# PLANNING AMENDMENT

| <b>SITE ADDRESS DETAILS</b><br><b>55 STATION ROAD, SURFLEET</b><br><b>SPALDING, PE11 4DB</b>                                                |                                                                         |
| <b>CURRENT APPLICATION NO:</b><br>This amendment cannot be considered unless the relevant reference is stated.                              | <b>55 Station Road H17-1199-21</b>                                      |

| <b>FULL DESCRIPTION OF DEVELOPMENT OF CURRENT APPLICATION THAT THIS AMENDMENT RELATES TO</b>                                                                                             | BARN / WORKSHOP BUILDING                                                                                                                                                                                                                                                         |    |

Plan No. 101A

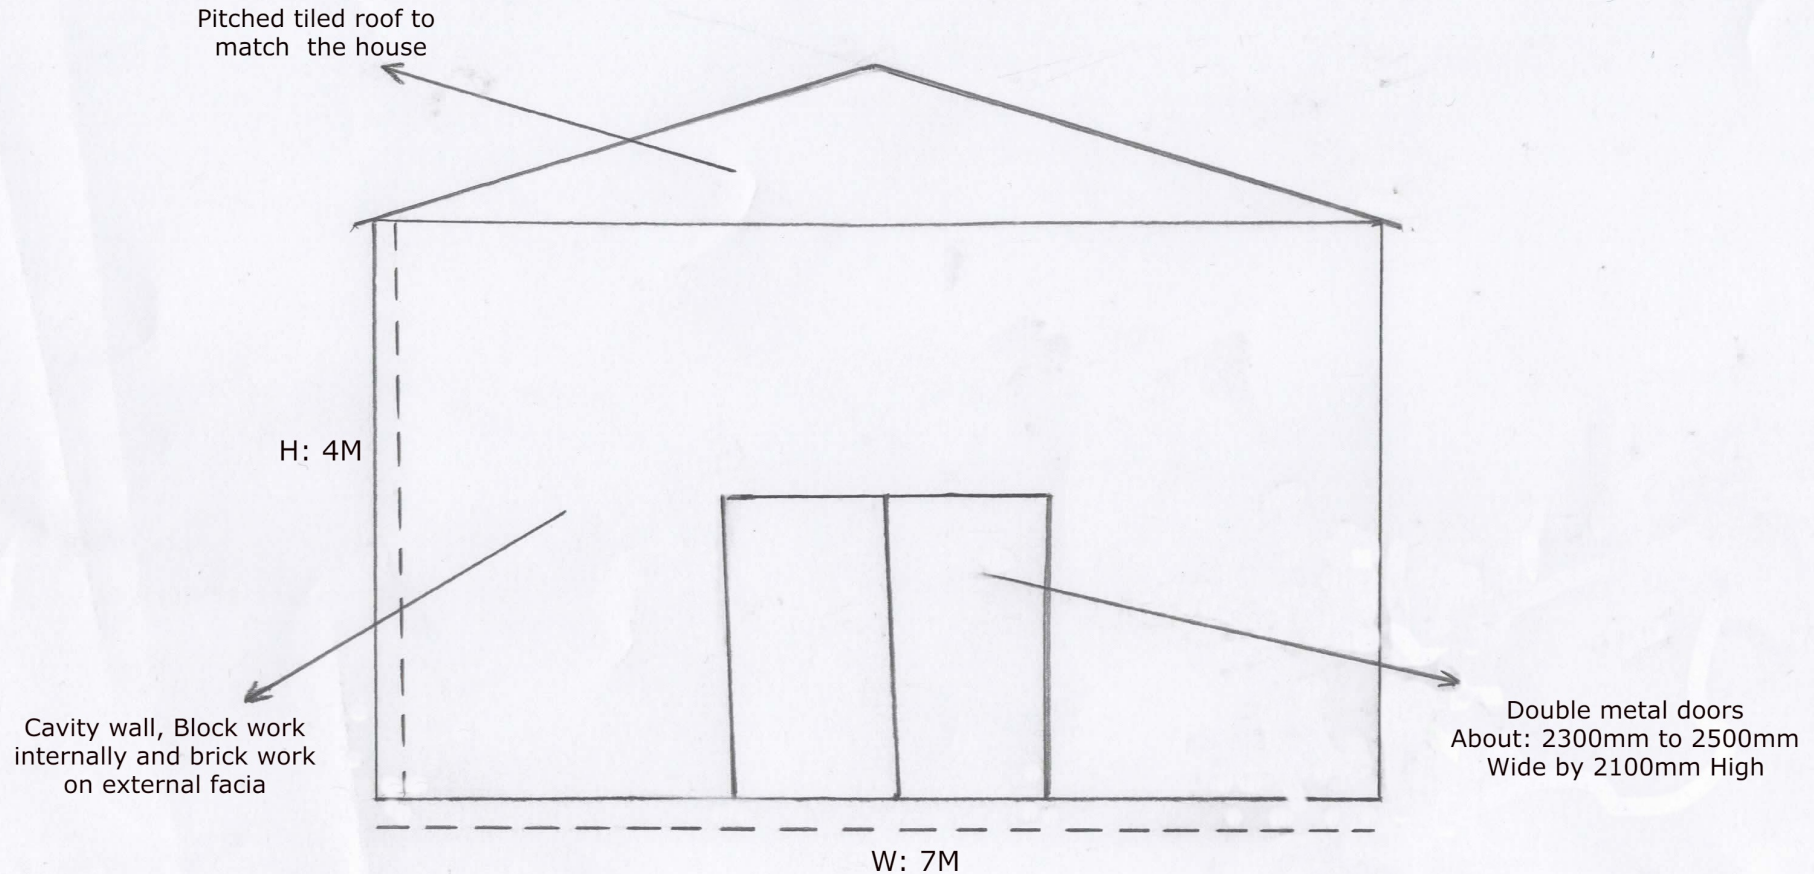
| State details of amendments proposed. (Give a full detailed list of the changes, and also mark these clearly on the accompanying plans. Only the changes listed here will be considered) | All the walls will be cavity wall, walls will be built with block work from inside and outside will be red brick work and tiled roof. Main entrance door on the front elevation will be about H: 2300mm to 2500mm wide and about 2100mm high, double metal doors will be fitted. |    |
| Describe any part of the original development which is excluded by virtue of the amendment, and state any alteration to plot numbers                                                     | These changes are only effecting the front elevation and they are not effecting any other parts of the building.                                                                                                                                                                 |    |
